Development Facilitation Team (DFT) – Review Comments

Project No: PR-2022-006674

Legal Description: LOT 16 & 17, LAND OF RAYMOND ORTIZ

Application For: SD-2023-00197-PRELIMINARY/FINAL PLAT (DHO)

**Plat for  
Lots 16-A and 17-A,  
Land of Raymond Ortiz  
Being Comprised of  
Lots 16 and 17,  
Lands of Raymond Ortiz  
City of Albuquerque  
Bernalillo County, New Mexico  
January 2024**

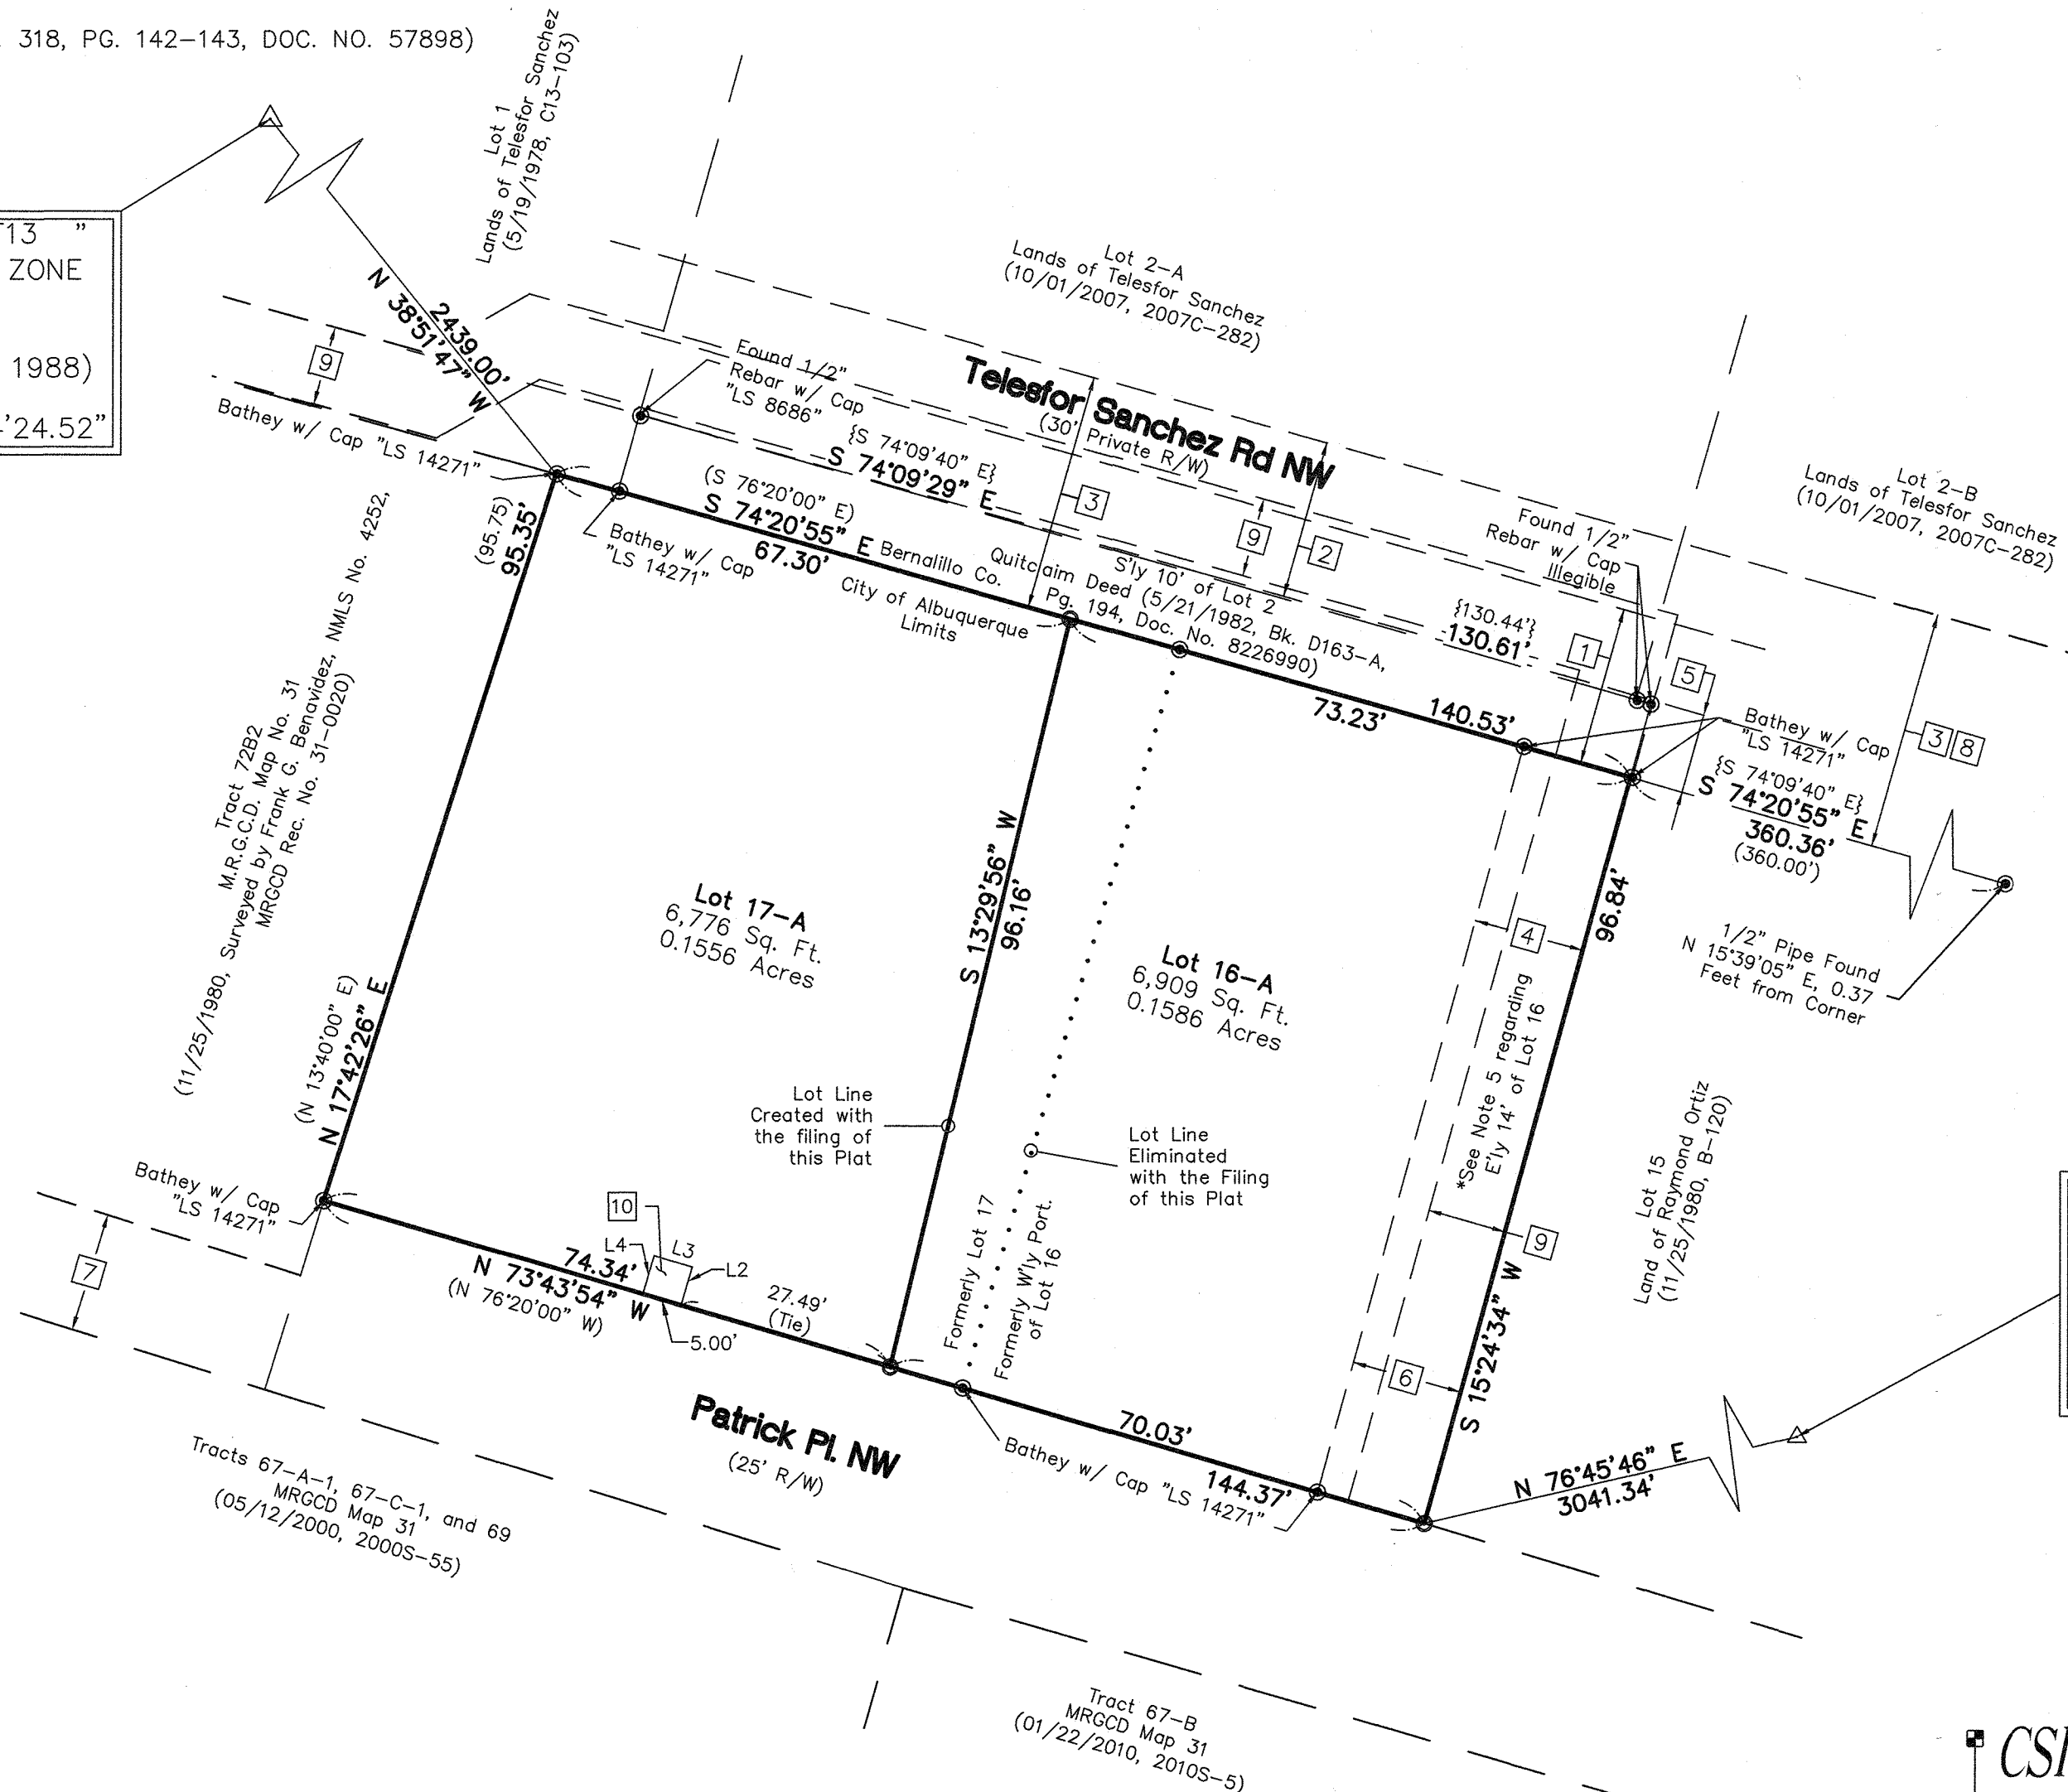
- **On Sheet 3 of the Plat, ZHE Variance notes are included from the required 10-foot side yard setback, 75-foot minimum lot width, and lot size requirements. Proof of approval of the ZHE Variances and submittal of the Notices of Decision for the approvals must be submitted prior to the approval of the Plat by the DHO.**
